Diane Sarkies - NWRL Cherrybrook Station Robert Road

Application No: (SSI-5414)

Our Submission: Attention Director, Infrastructure Projects

Figure 6.12 Cherrybrook Station - Indicative vehicle and pedestrian movements

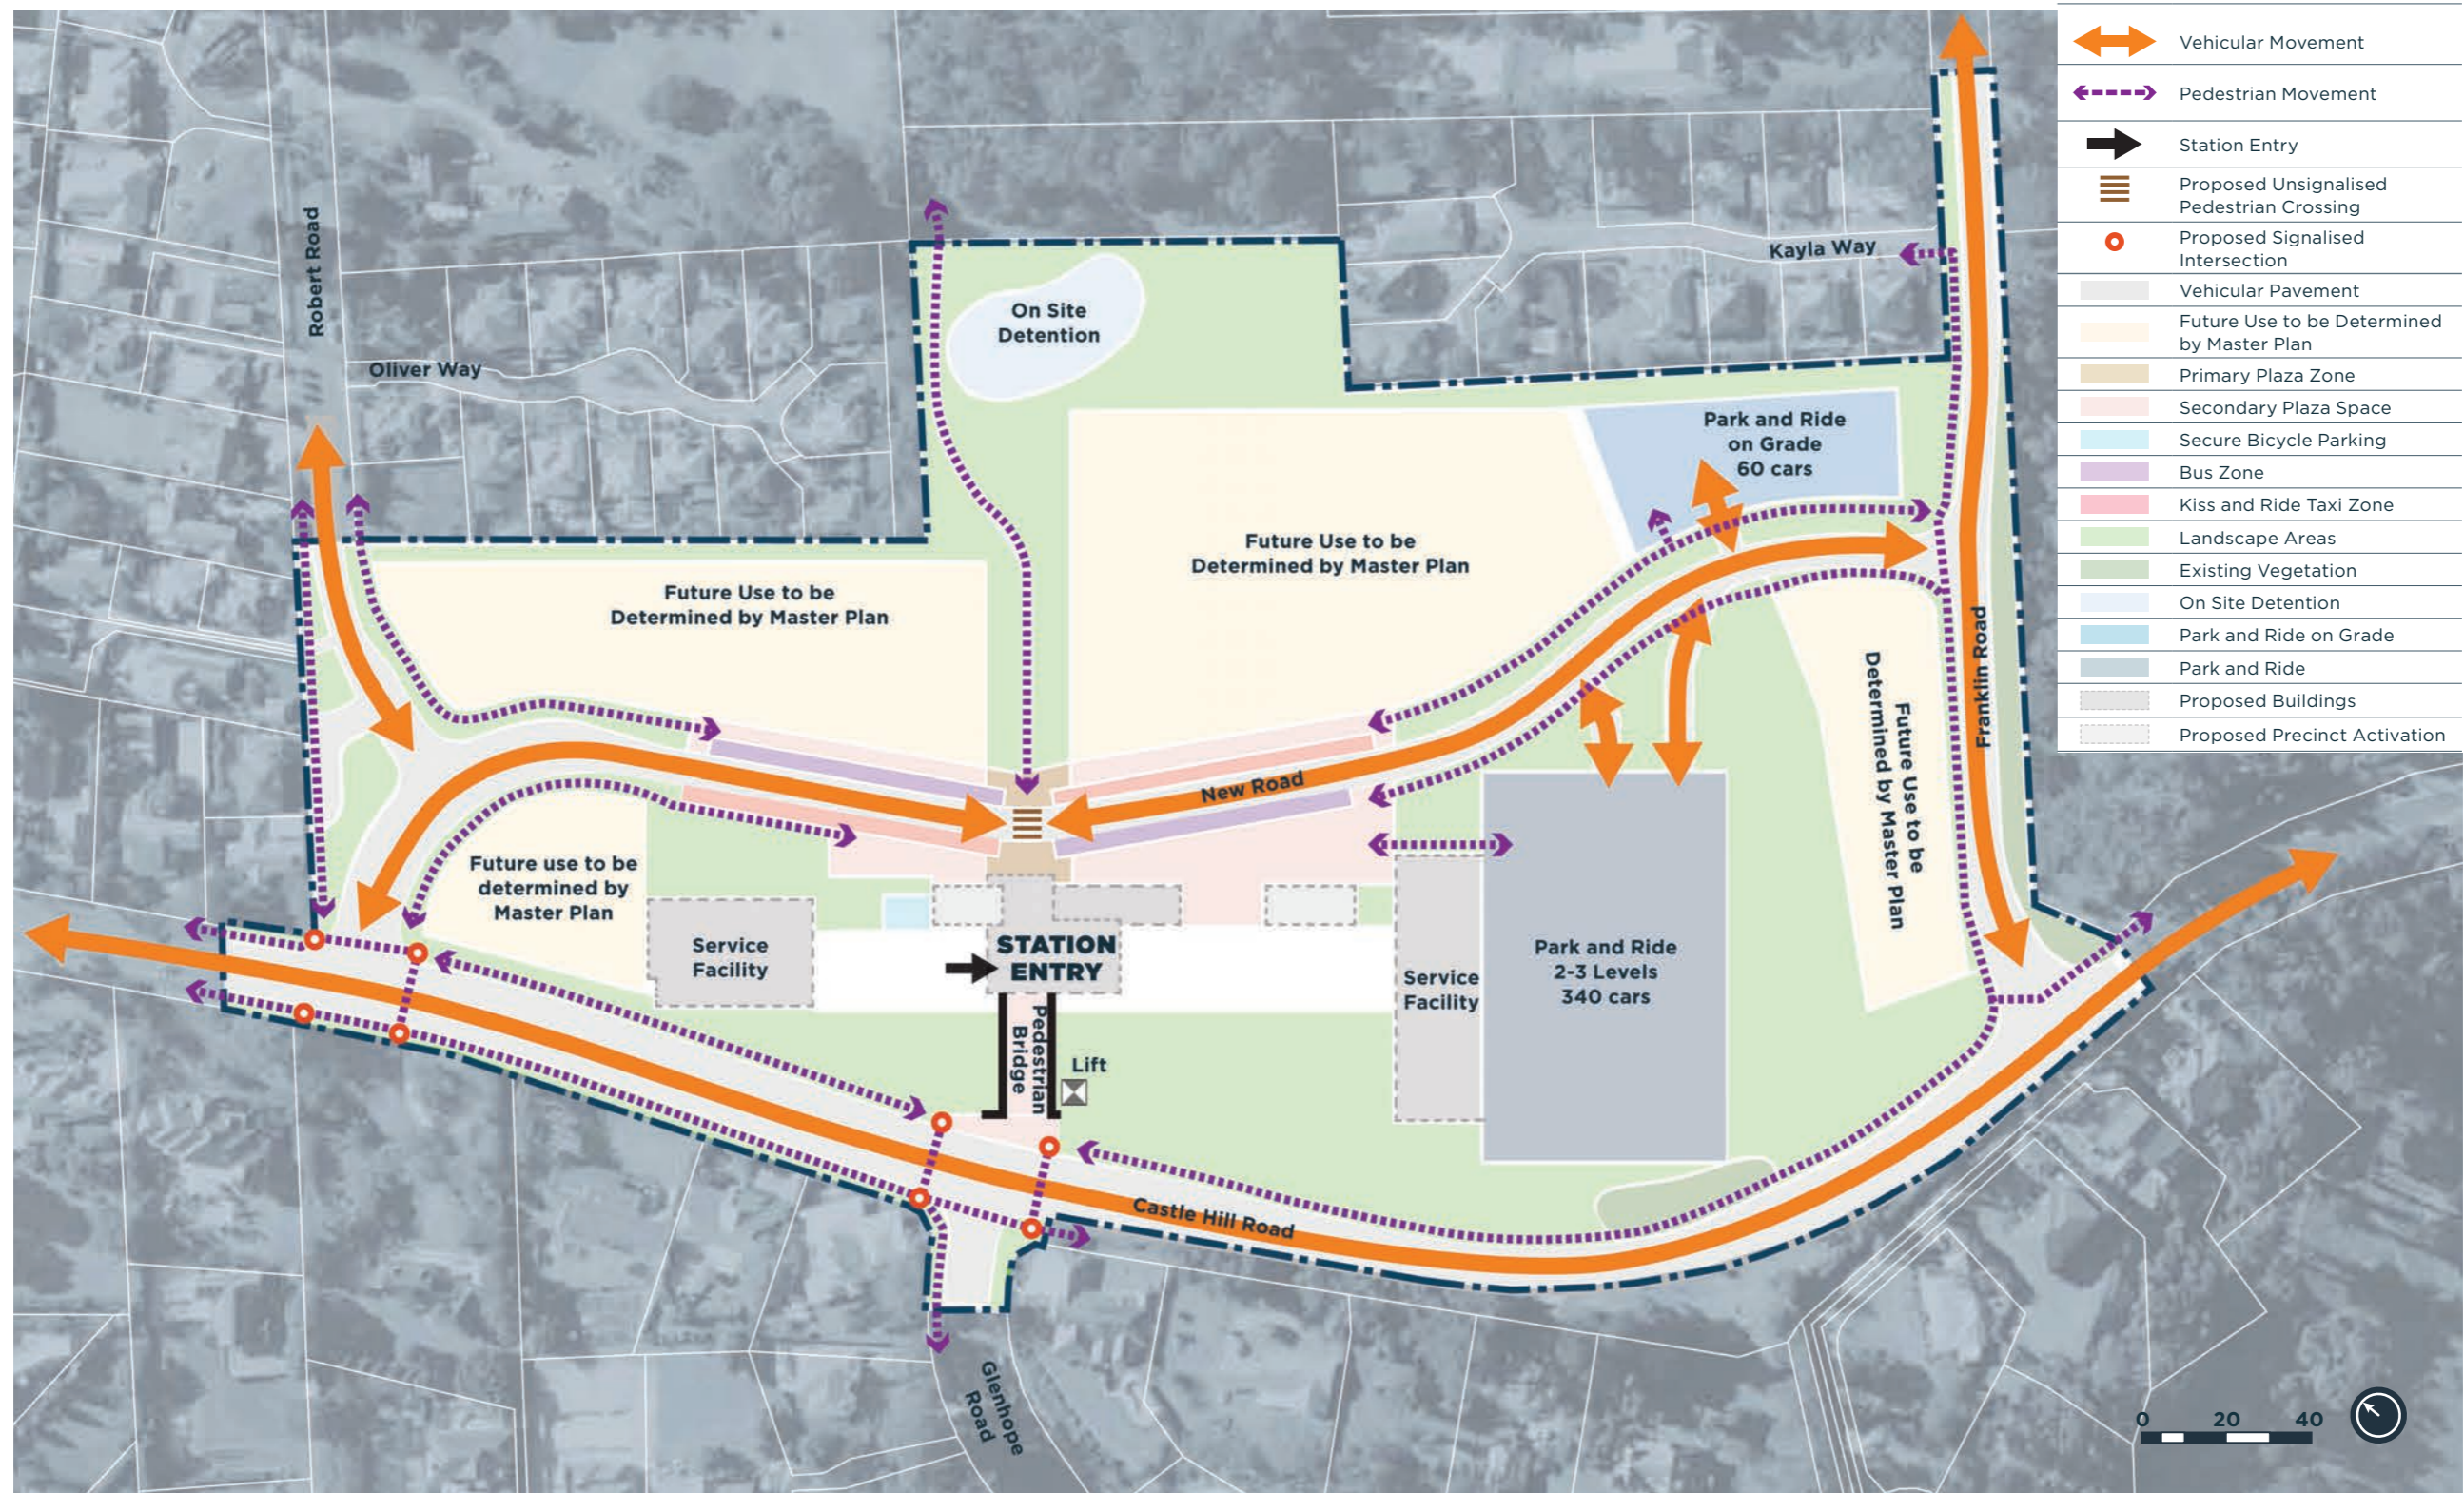
We understand that Robert Road is to be used to gain access to the station by way of John Road then into Robert Road. This is not acceptable.

We also understand that on street parking on either side of the road is to be eliminated as an alternative.. This also is not acceptable

Further we understand that a proposal could be considered to make Robert Road a one way road. This is not acceptable.

We cannot see any reason why the already established route along County Drive then turning left into Castle Hill Road cannot be fully utilised to gain access to Cherrybrook Railway Station.

The main points about this route are that the County Drive Road was established as a main arterial 4 lane Road with the already established divider in the middle of the road.

At the bottom of the hill there is also currently a dog leg with double lines marking the centre of the roadway.

Buses will not be able to navigate this bend in the roads without crossing the lines.

Ordinary cars are unable to navigate this dog leg without crossing the lines now. Buses will be worse off.

The entries of buses from County Drive into John Road already have to go to the centre of County Drive to enable them to turn left into John Road. There is ample evidence that the buses serving John Road regularly mount the footpath in an endeavour to navigate this corner.

In addition to the foregoing there is also a problem with traffic turning right from John Road into Robert Road as the traffic already sometimes cuts the corner and regularly crosses over into the oncoming traffic. With buses attempting to navigate this corner the problem will be greatly compounded. Further there is the ever going problem of exhaust pollution from buses which will affect the elderly and disabled, together with those with breathing problems of which I am one who suffers from COPD. The proposed added exhaust pollution will have a profound affect with my already deteriorating health.
